July 14, 2020

**RE: Woodmen Hills Metropolitan District
West Concrete Water Storage Tanks
Site Development Plan (PPR-20-0017) – Comment Response Letter**

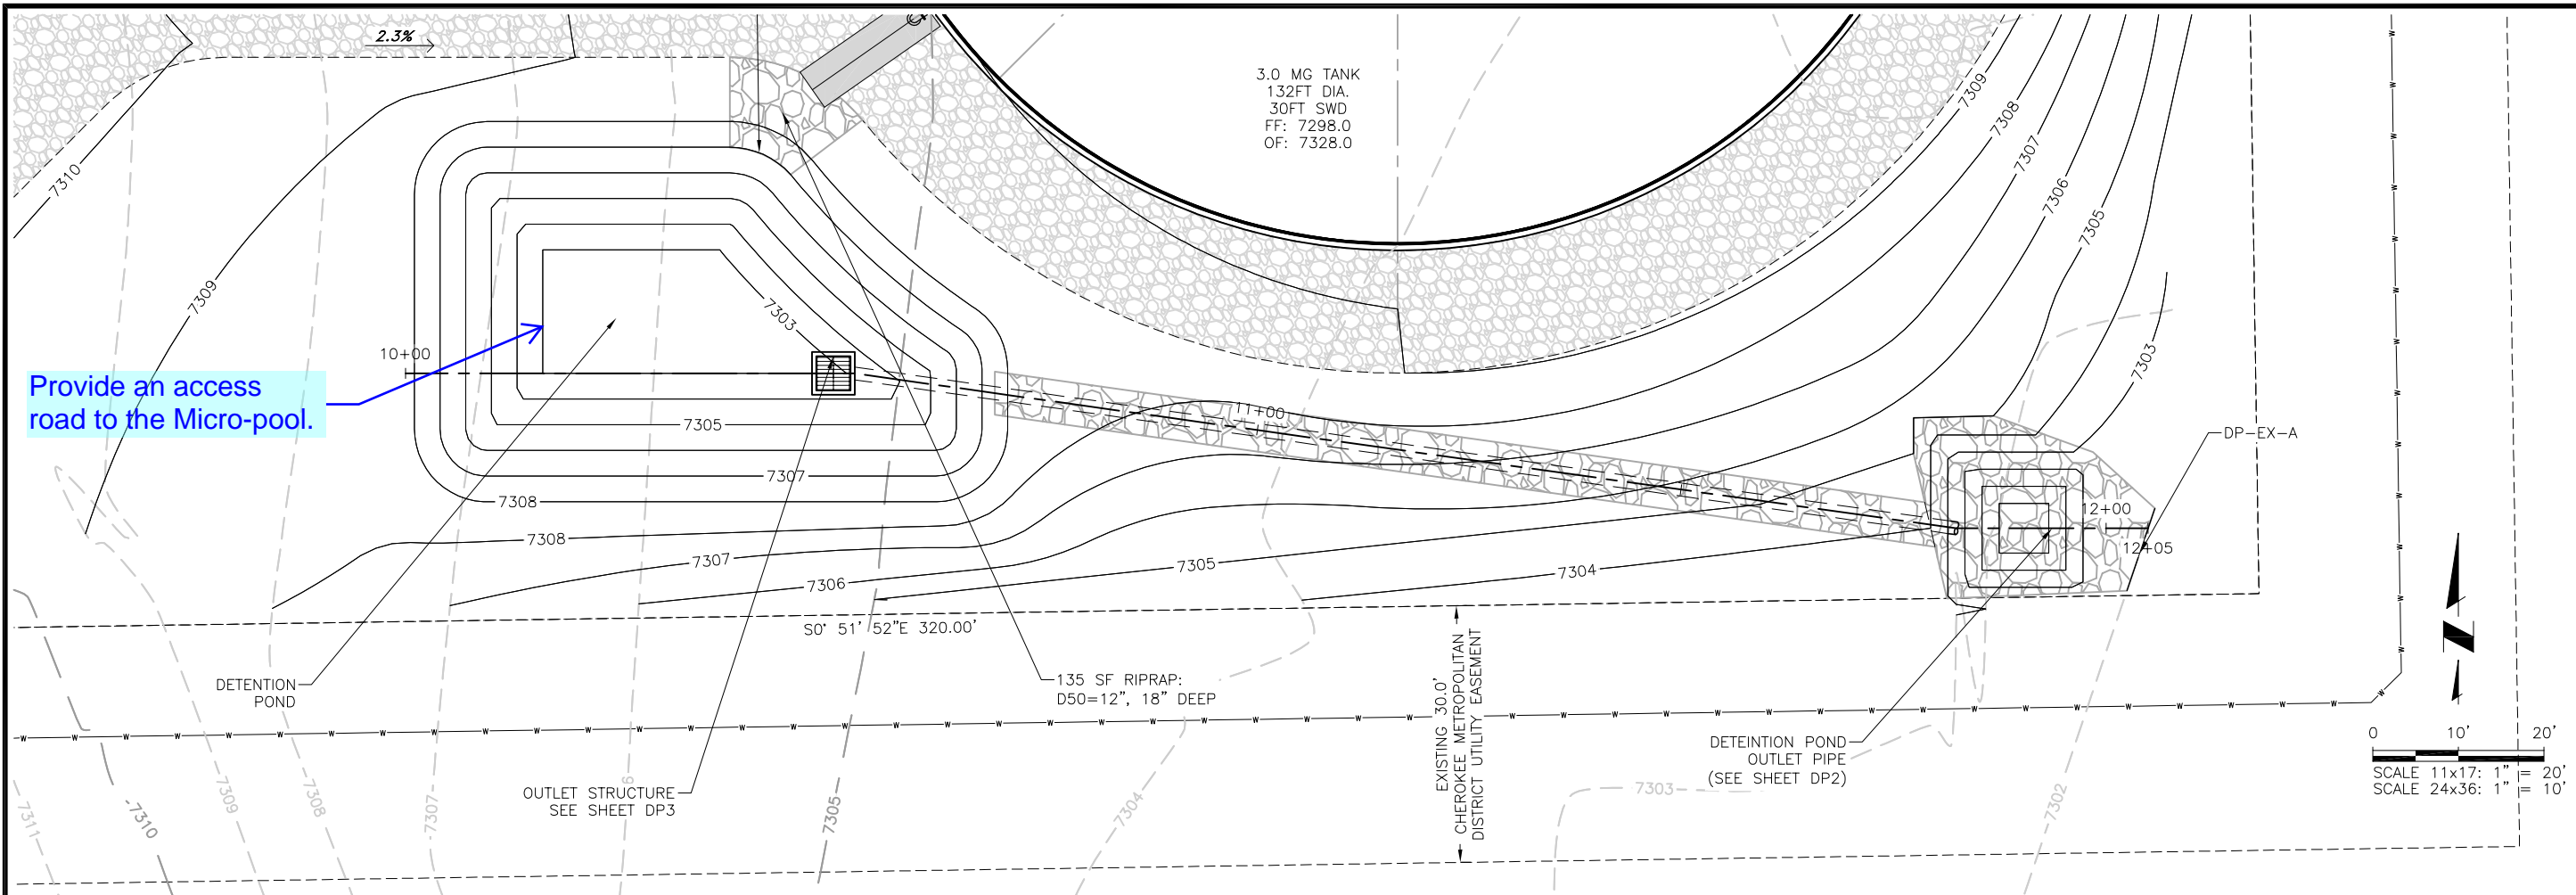
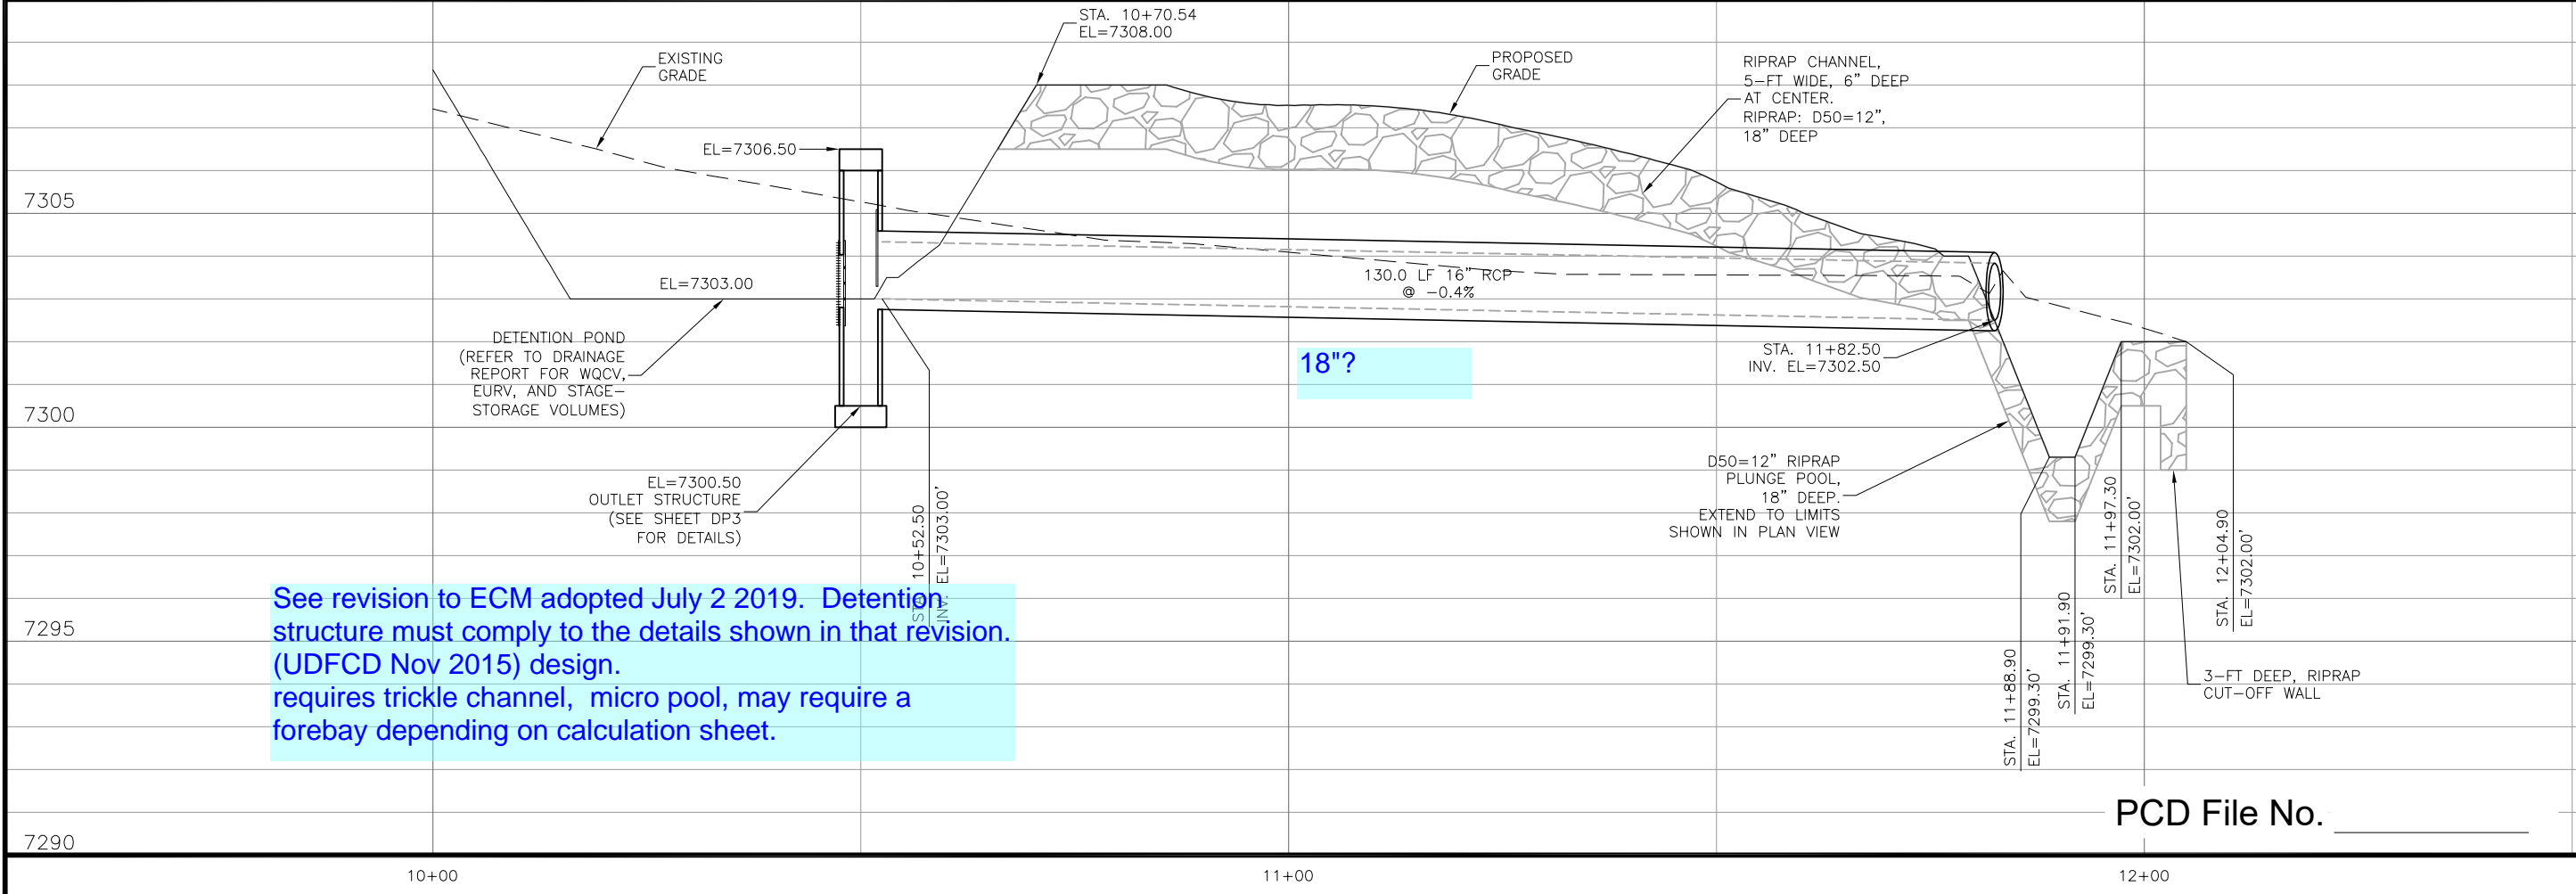
13. Appendix F, DP2: Provide an access road to the micro-pool. See revisions to ECM adopted July 2, 2019. Detention structure must comply to the details shown in that revision (UDFCD Nov 2015) design. Requires trickle channel, micro-pool, may require a forebay depending on calculation sheet.. 18 inch RCP?

Due to the small size of the detention basin, an access road located on the dam crest will be used to access/clean out the outlet structure using a backhoe. Outlet structure revised to comply with the details in the UDFCD November 2015 design. Calculations for the detention basin sizing and outlet structure have been revised in Appendix E. In addition, a concrete trickle channel has been added to convey concentrated flows to the outlet structure where the micro-pool is located within the proposed outlet structure. A forebay is not required due to the small size of the site and detention basin as shown on the design procedure form in Appendix E. The outlet pipe was changed to 15-inch RCP. Revised drainage sheets are included in Appendix F.
